Grandview Reserve Phase 1 Traffic Impact Analysis (LSC #S214240) August 12, 2021

LSC Responses to TIS Redline Comments

Figure 12a
Year 2041
Total Traffic

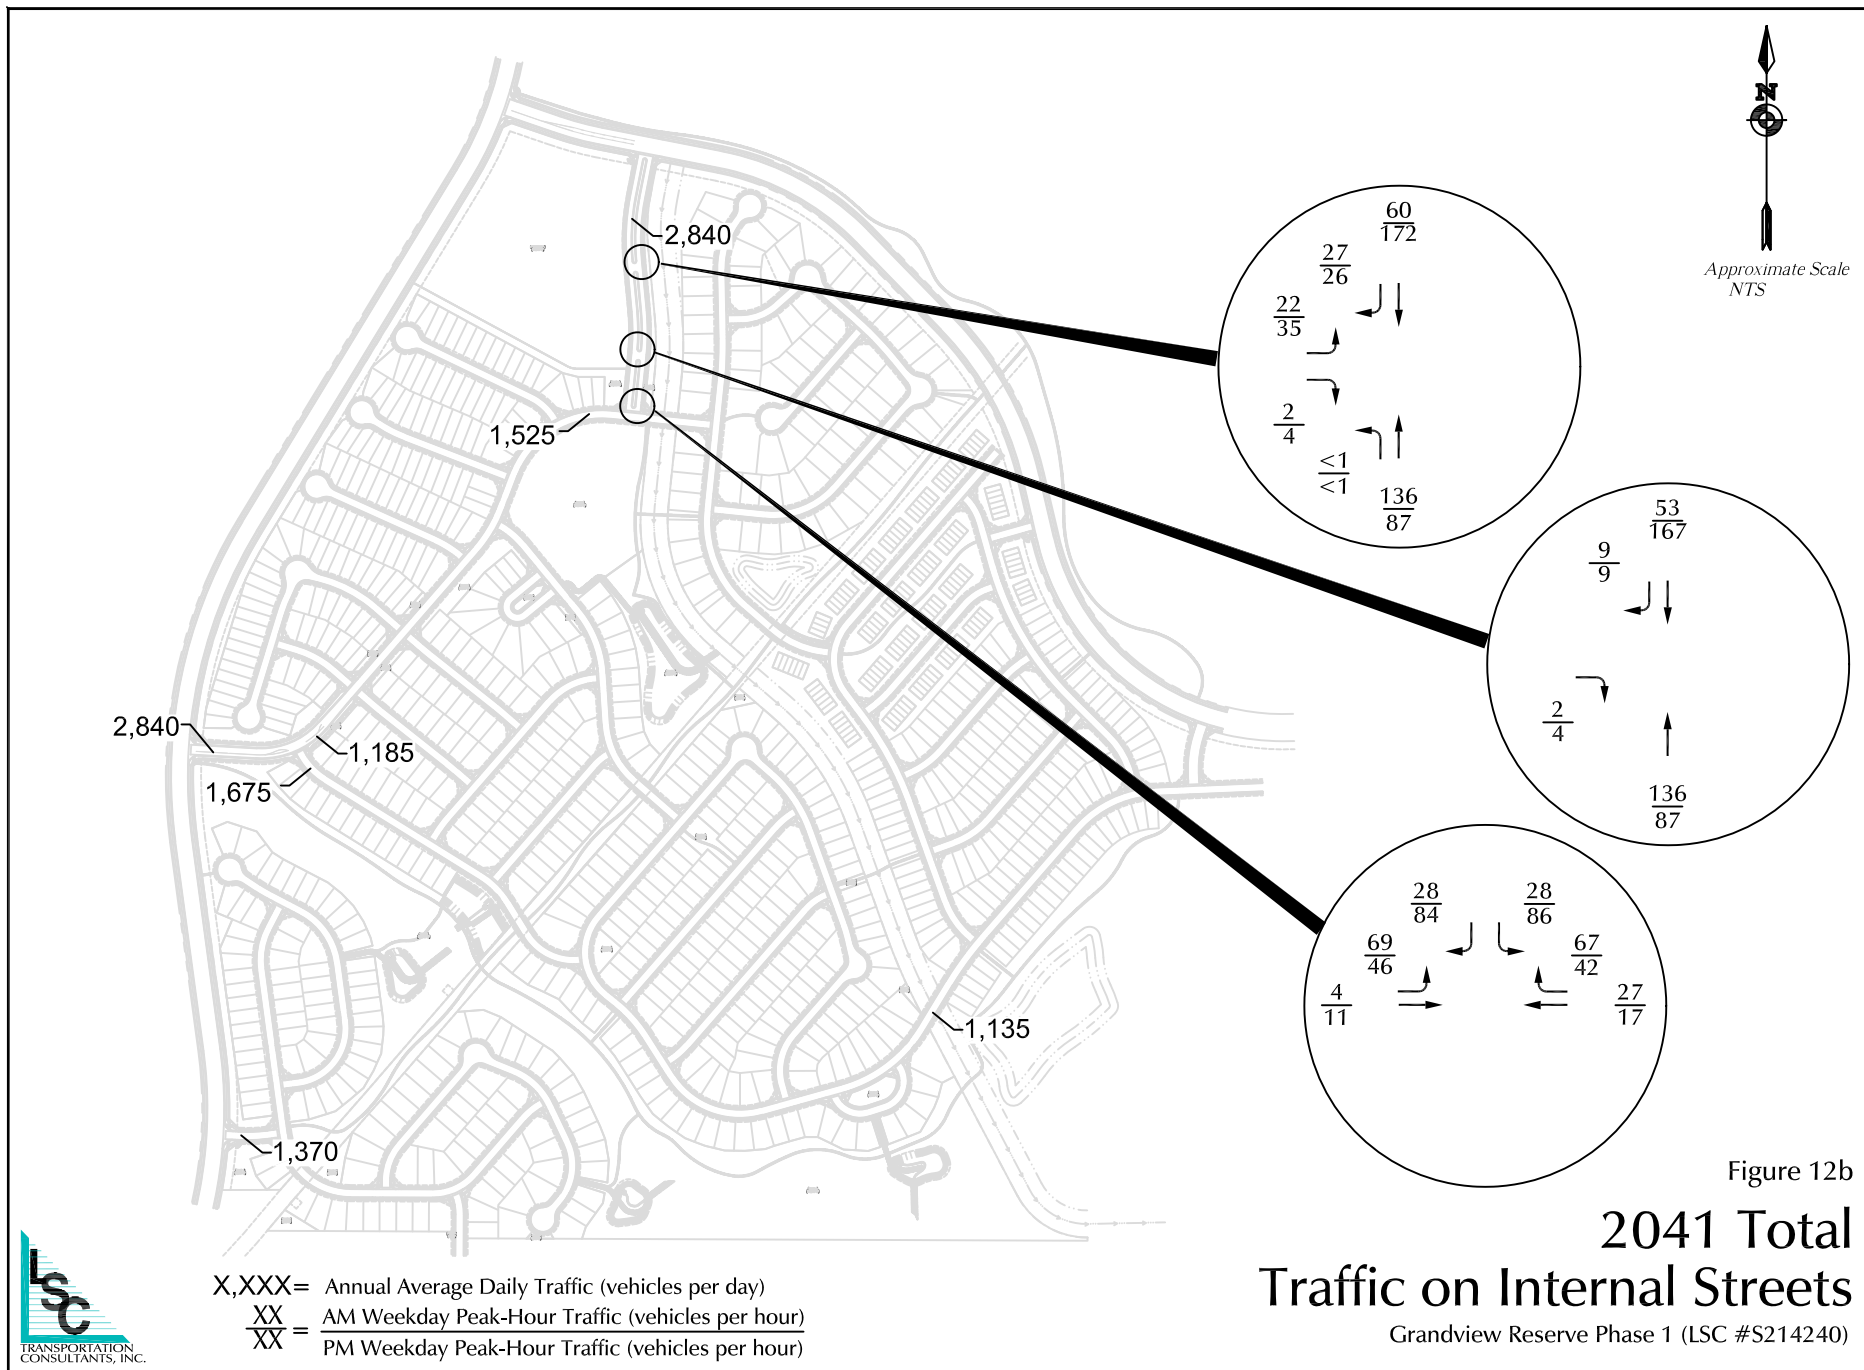
[include these intersections](#)

Author: kdferrin Subject: Sticky Note Date: 12/10/2021 2:34:38 PM
LSC Response: The requested analysis has been included in the updated TIS.

Figure 2b

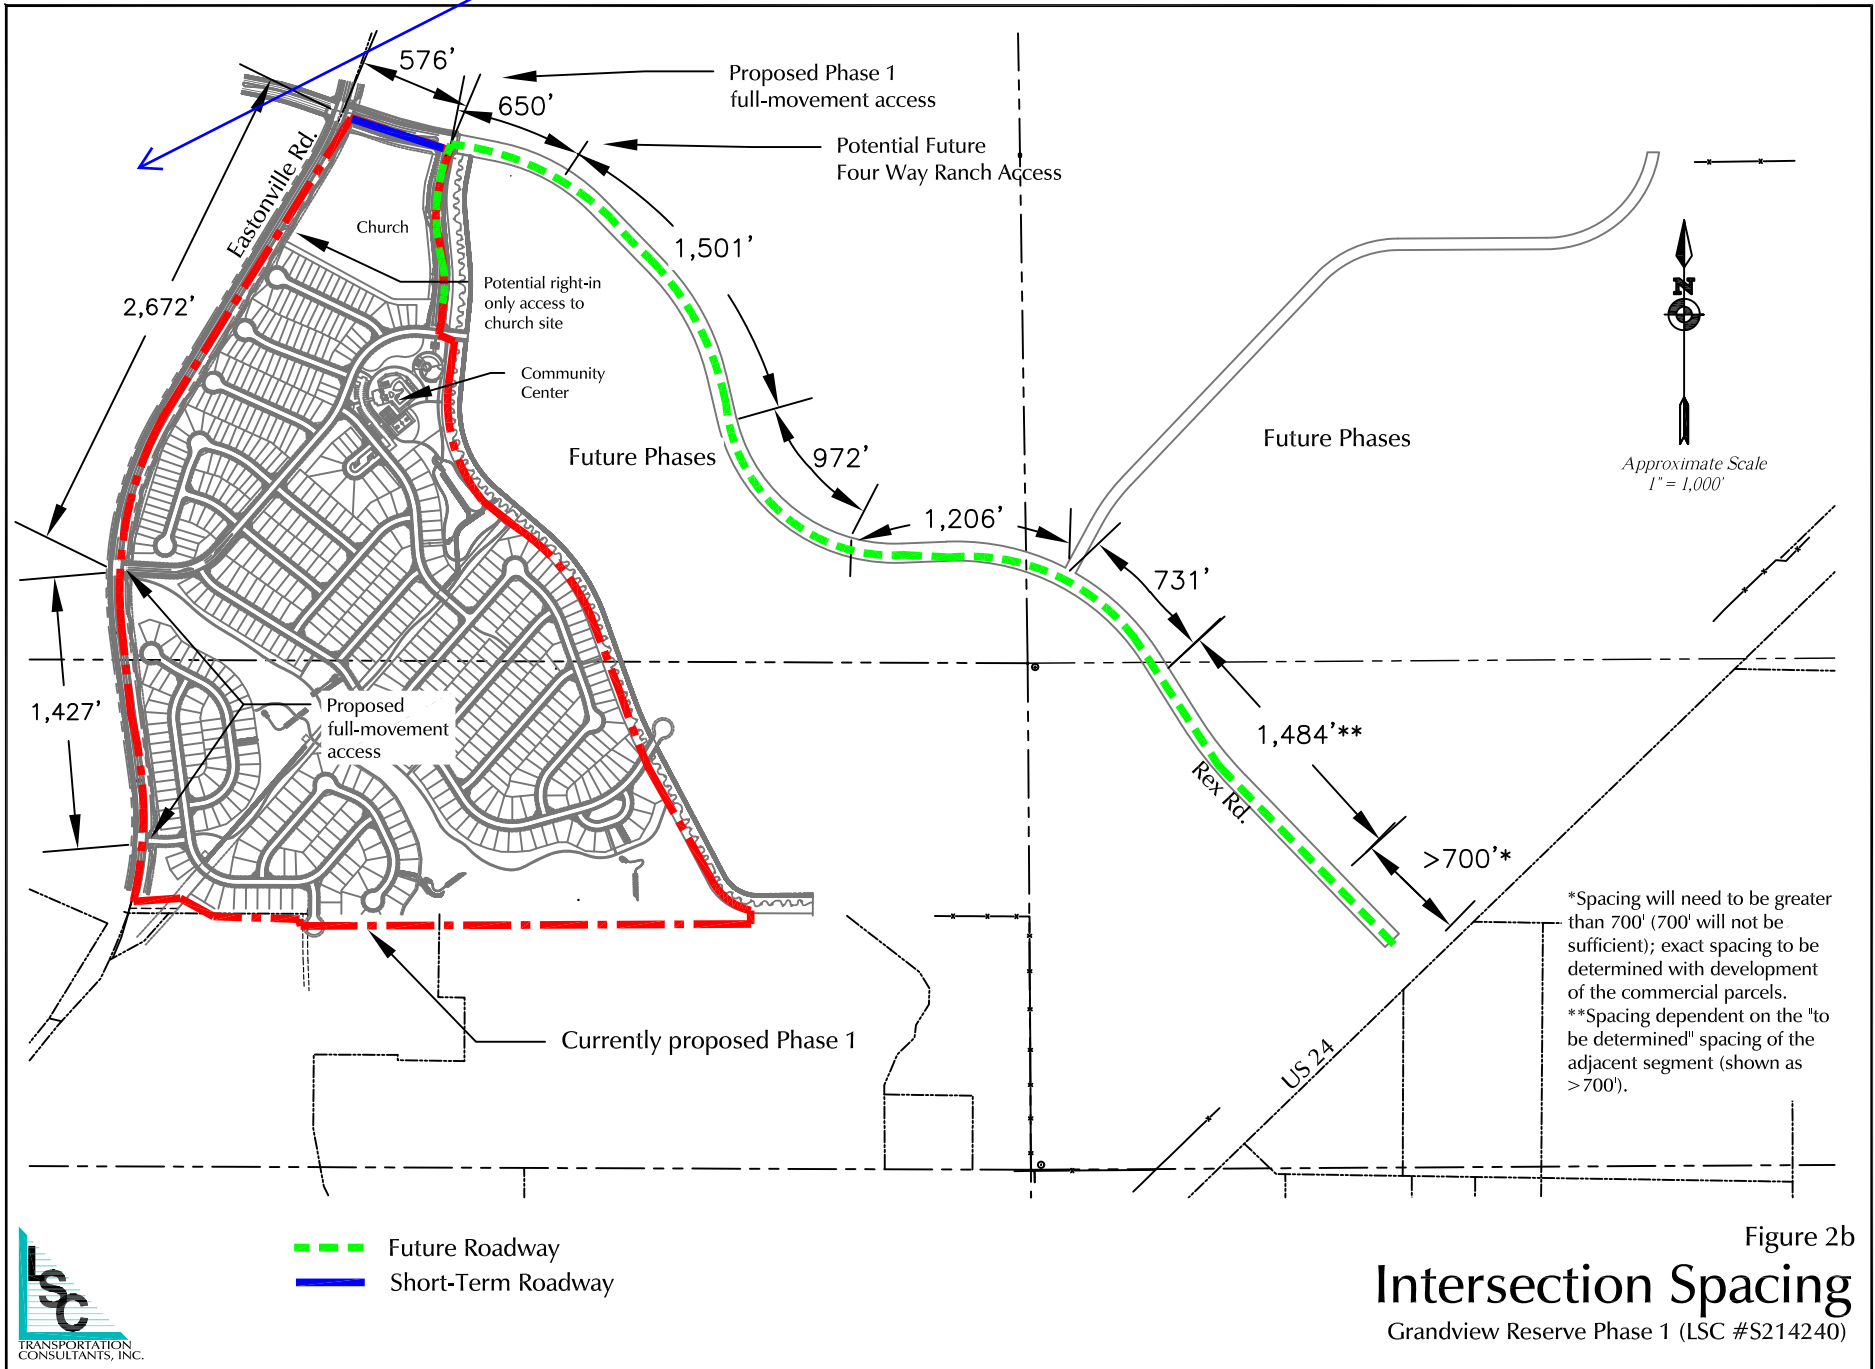
650' (minimum) will be acceptable

This needs to be >700'

Author: kdferrin Subject: Sticky Note Date: 12/9/2021 1:26:54 PM
LSC Response: Revised as Requested

Author: kdferrin Subject: Sticky Note Date: 12/9/2021 1:27:24 PM
LSC Response: Revised as requested
